# Cambridgeshire County Council and Fenland District Council Relevant Representations

3.1 Matters relating to the crossing and use of the former railway line have been considered by the Transport Strategy Team in relation to the aspirations of the Wisbech Area Transport Strategy and the Wisbech Railway project being funded by the Cambridgeshire and Peterborough Combined Authority. These comments can be found in paragraphs 3.44-3.47. These comments are also made without prejudice to the response provided by the Transport Assessment Team in respect of trip generation and distribution, which may impact upon off-site junction layout/ geometry. In relation to Operational Access Figures 6.18i & 6.18ii, the comments below relate to proposed access infrastructure.

**Figure 10.1vii**  
**New Bridge Lane access proposal with Topographical Survey**

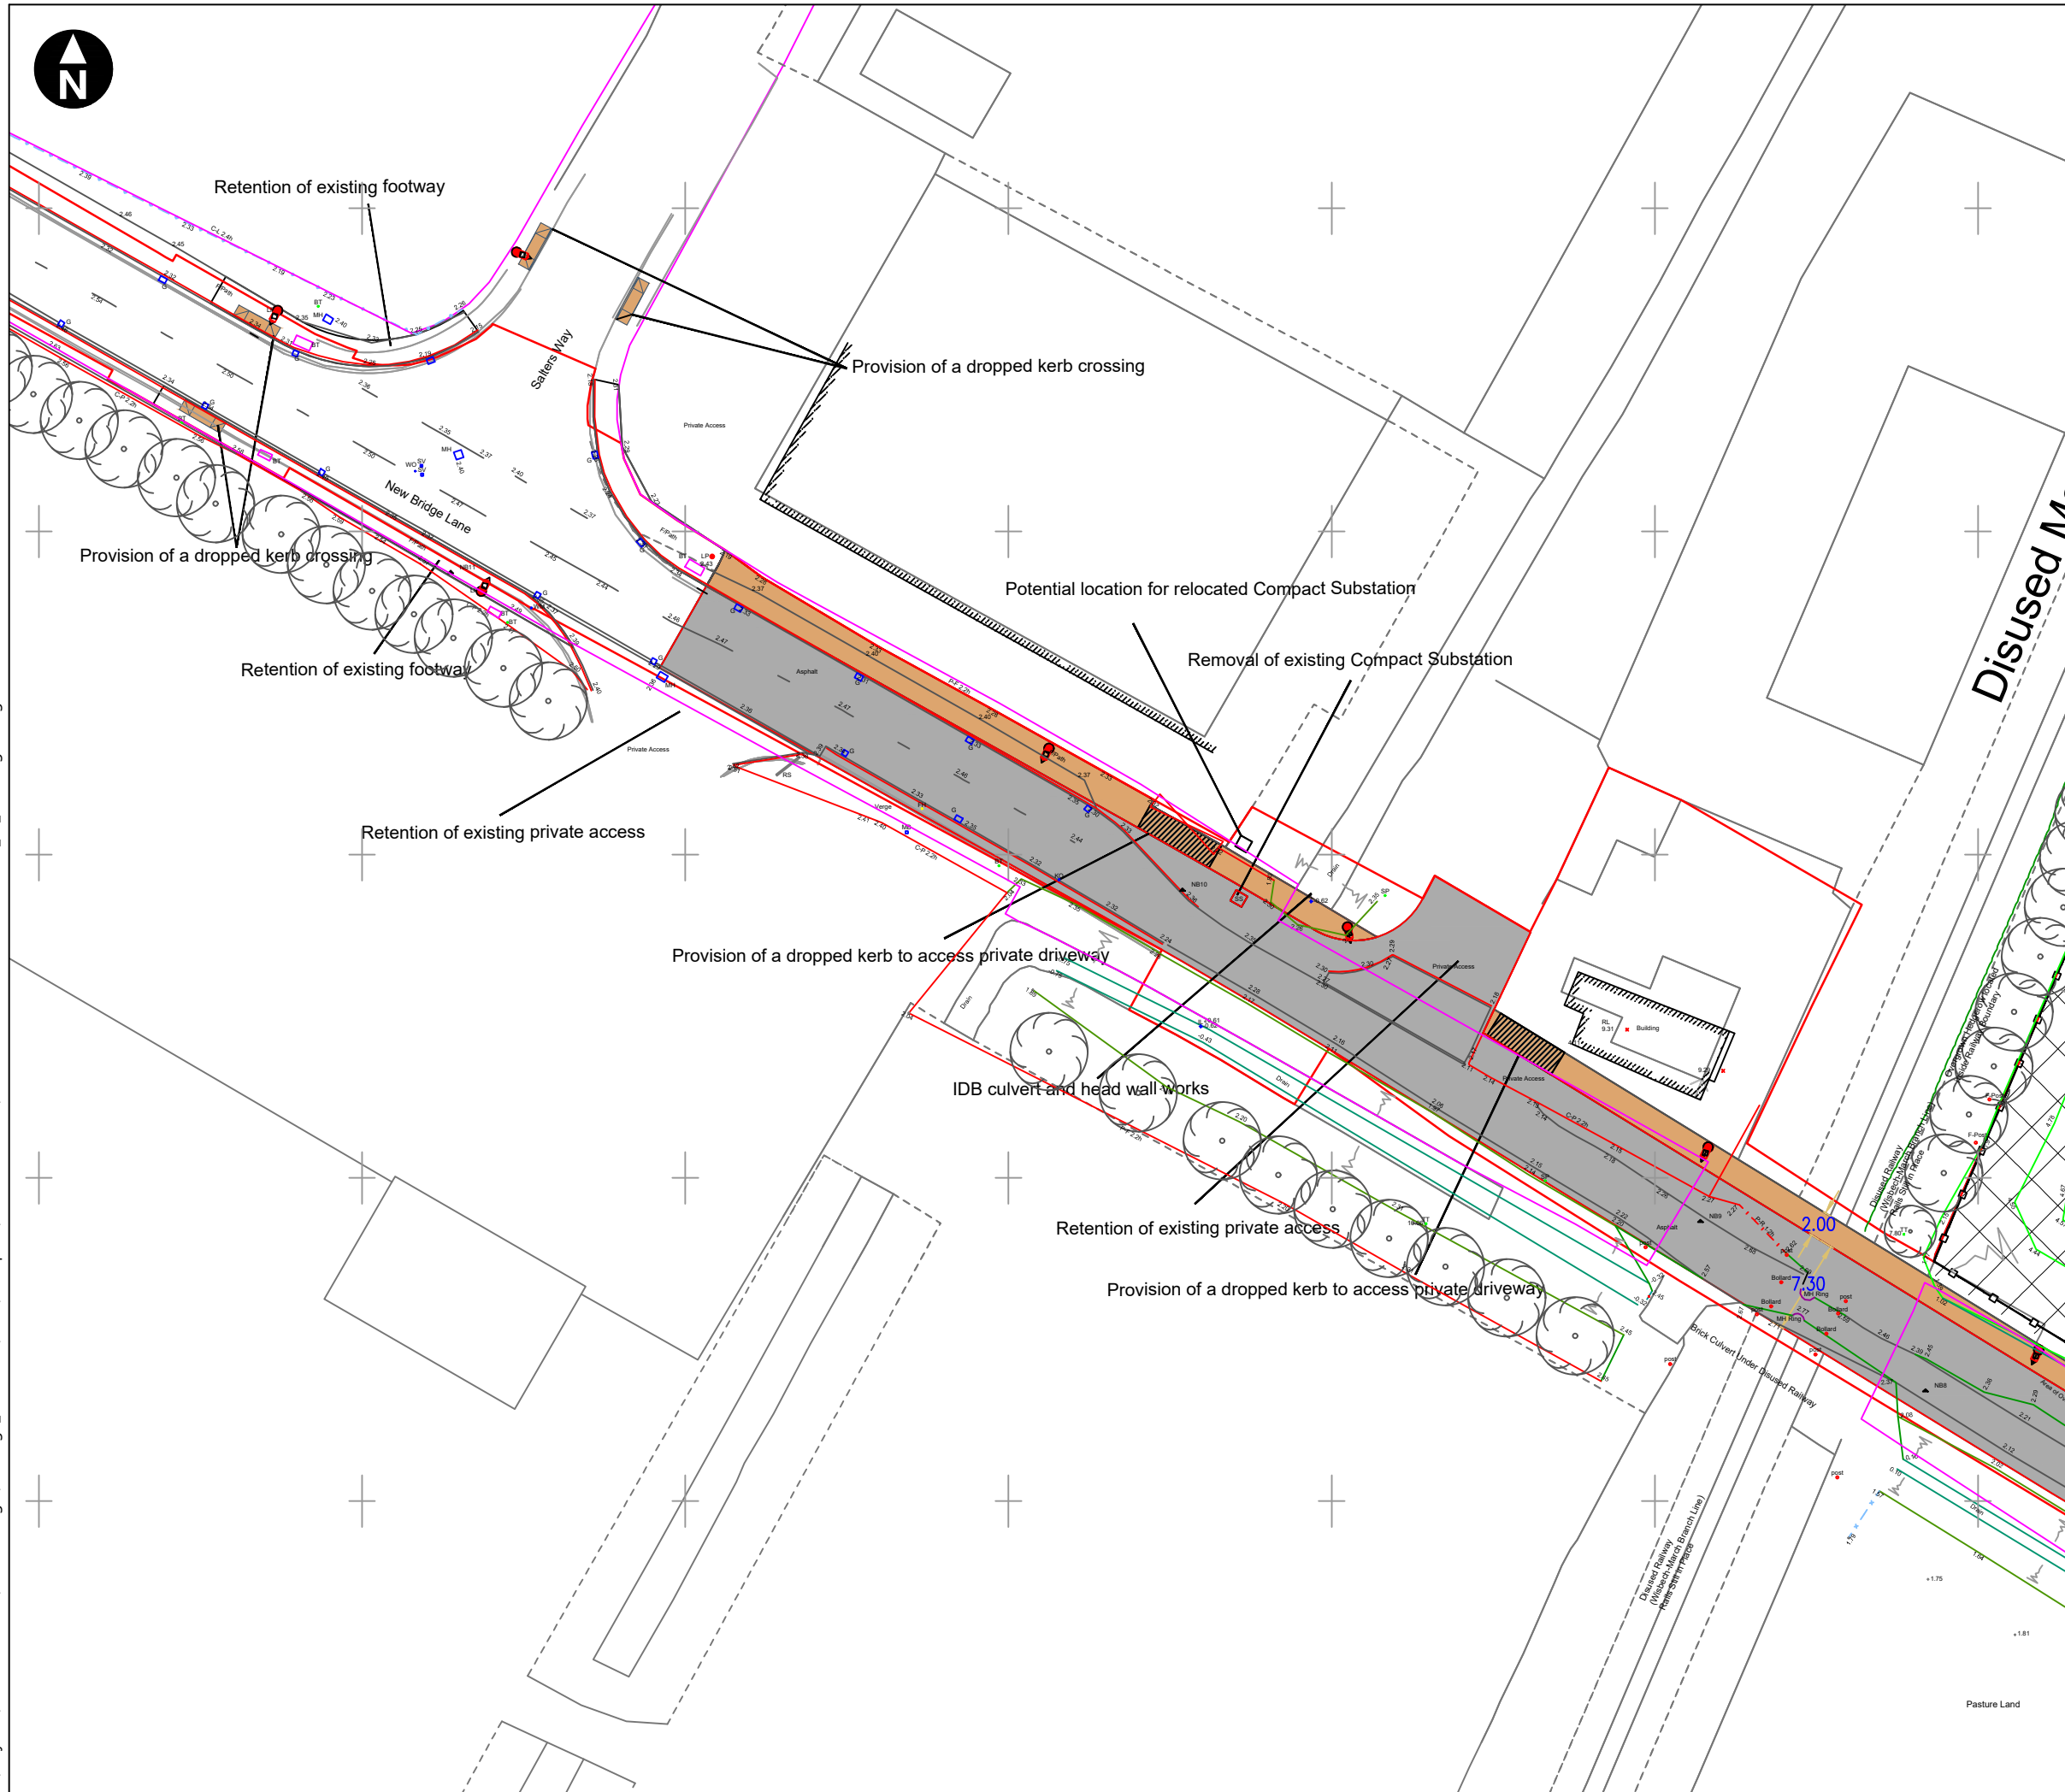
- 3.2 The principle of widening/ extension of New Bridge Lane is acceptable. However, there is an iteration of the access drawings available which are overlaid with topographic data, and these should be submitted as part of the DCO for consideration. For roads required for DCO works, highway boundary information should be sought from the Local Highway Authority (LHA), if it has not already been obtained. Highway boundaries should be marked on Access and Rights of Way (ROW) sheets and clearly included in the legend.
